Subject: CONSULTEE RESPONSE: 2021/92904 - Yangtze Chinese - pro-w objection
Date: 30 July 2021 09:58:59

DRAWING TITLE
EXISTING SITE PLAN
CLIENT

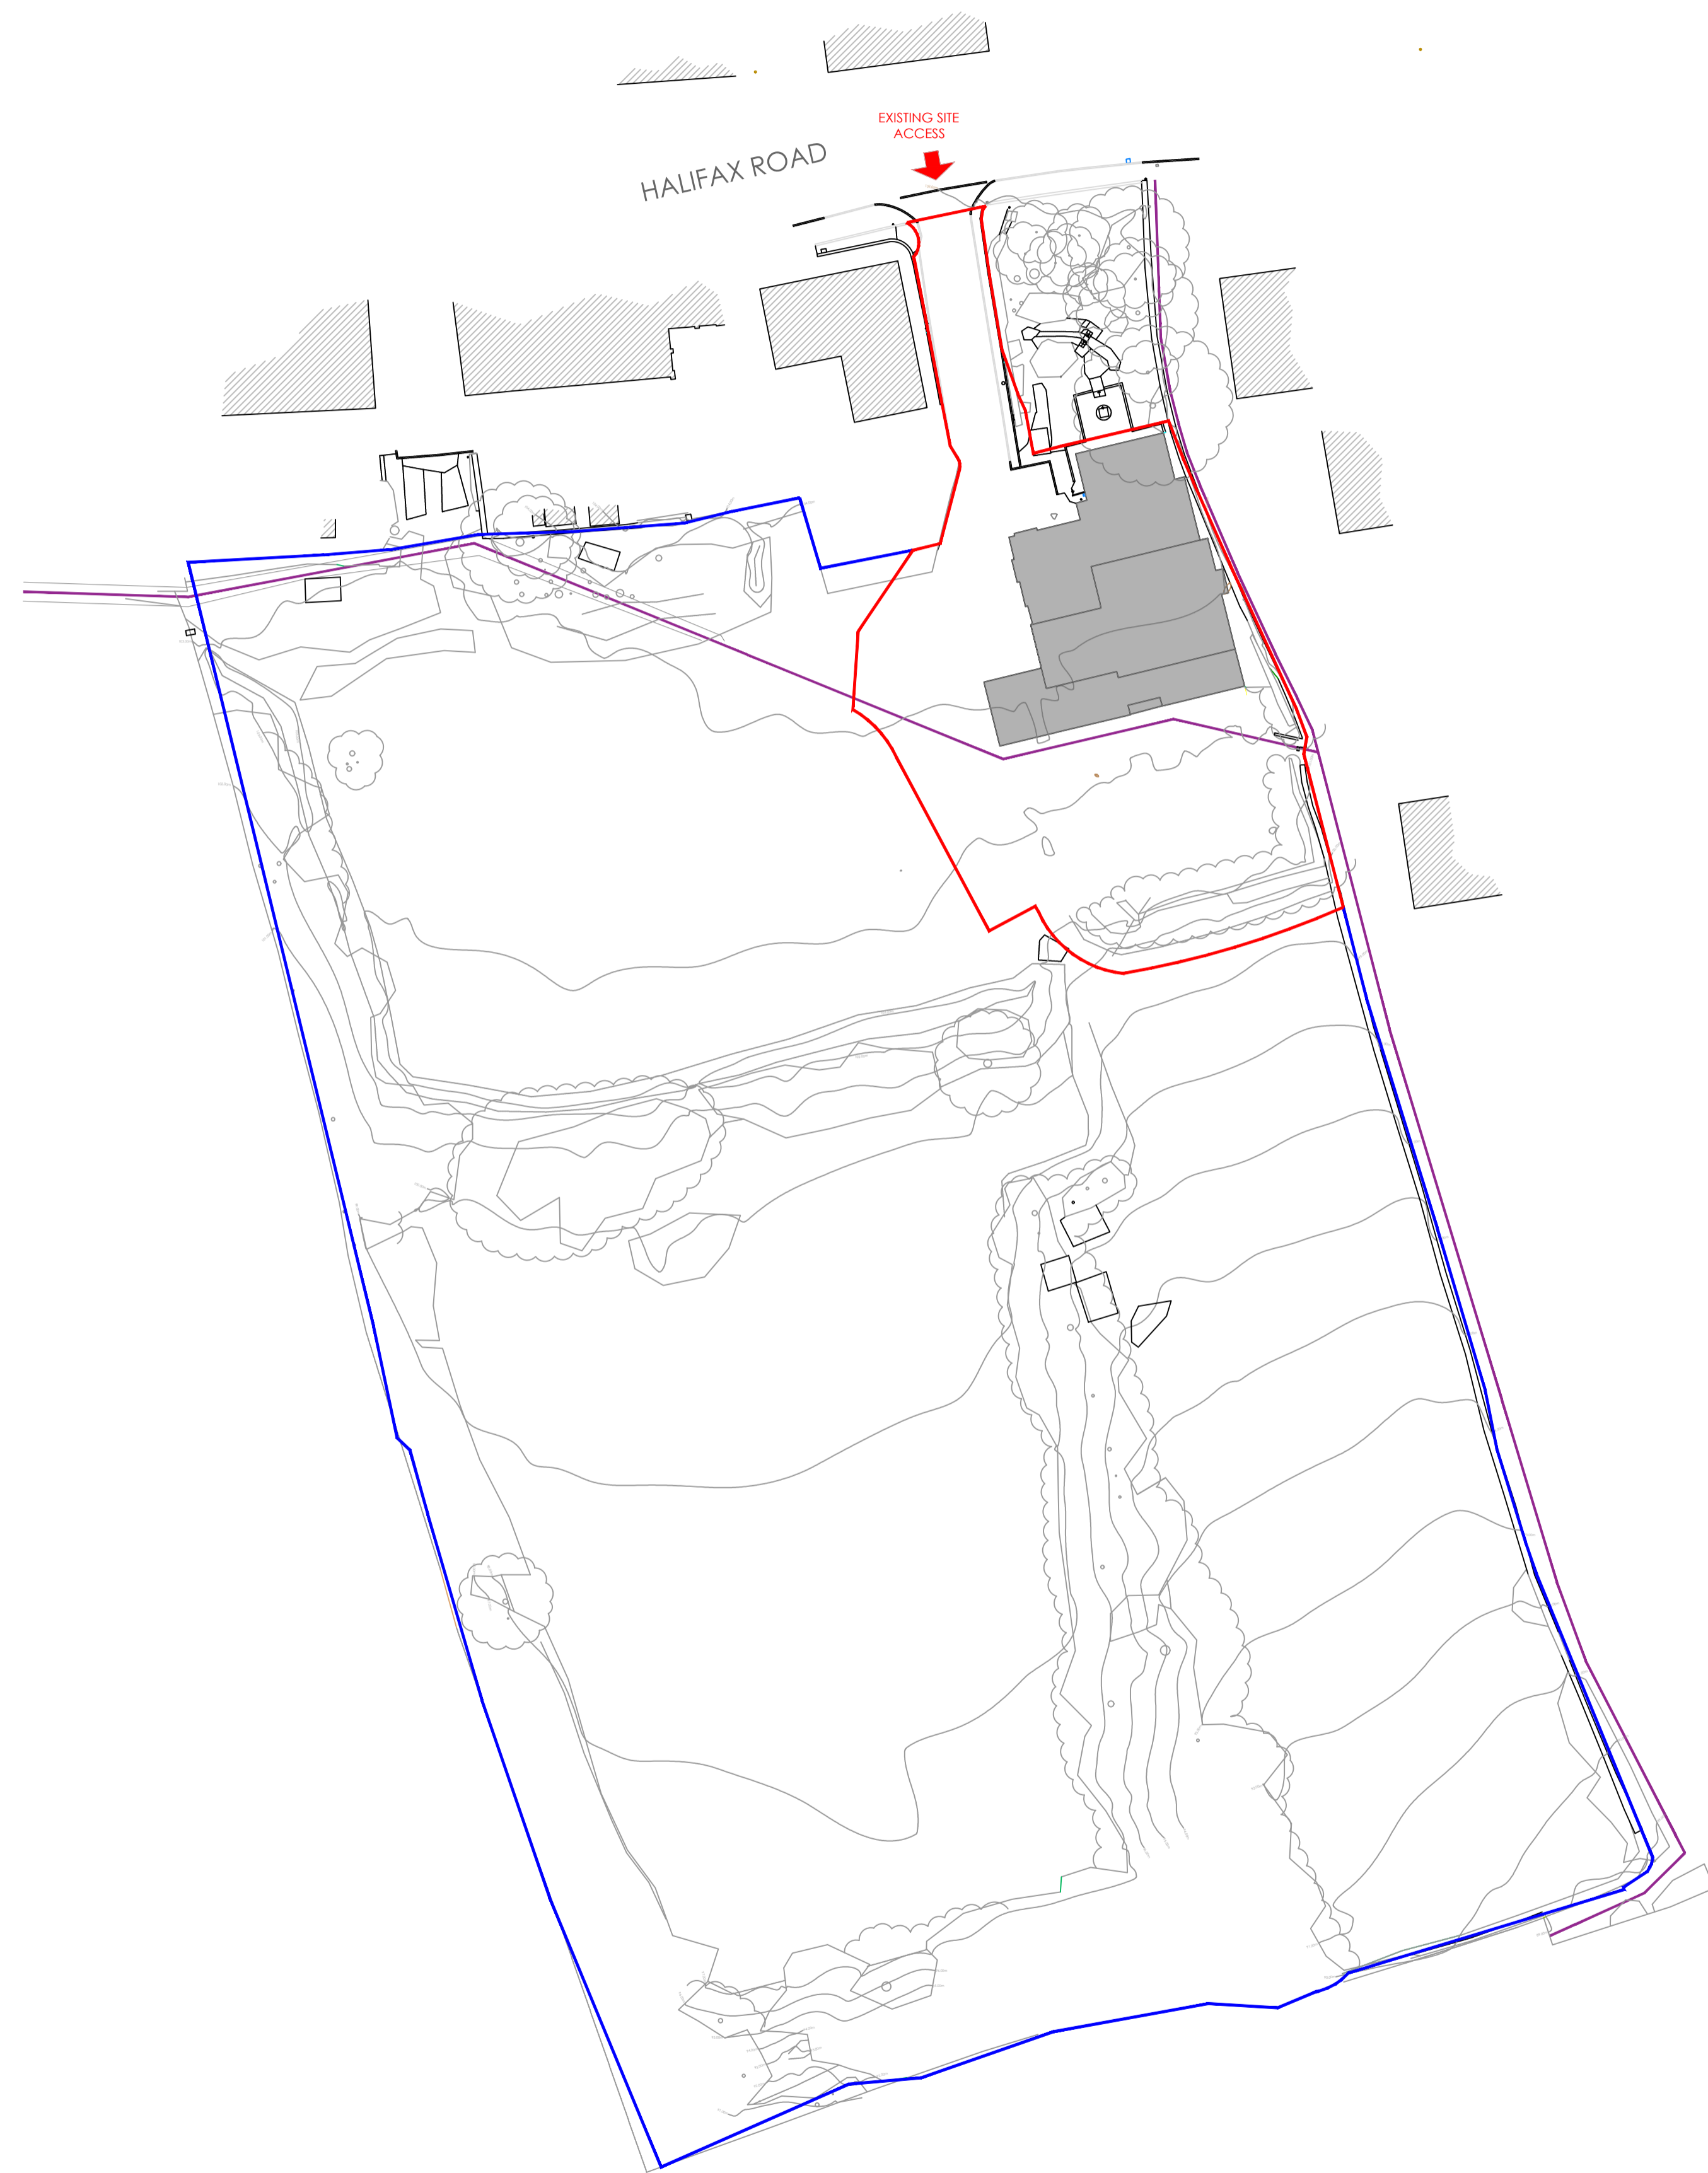
Public footpath Spenborough 114 is currently obstructed by a building. Although the applicant indicates that the footpath will be diverted pro-w would need further information. The aerial photo submitted with the proposed alignment of the footpath does not match the alignment on the proposed site/block layout

Any footpath diversion would be by separate process, application and cost with no guarantee of success.

Please confirm that public footpath Spenborough 113 to Halifax Road is to remain open and this path will not be used as access to the development
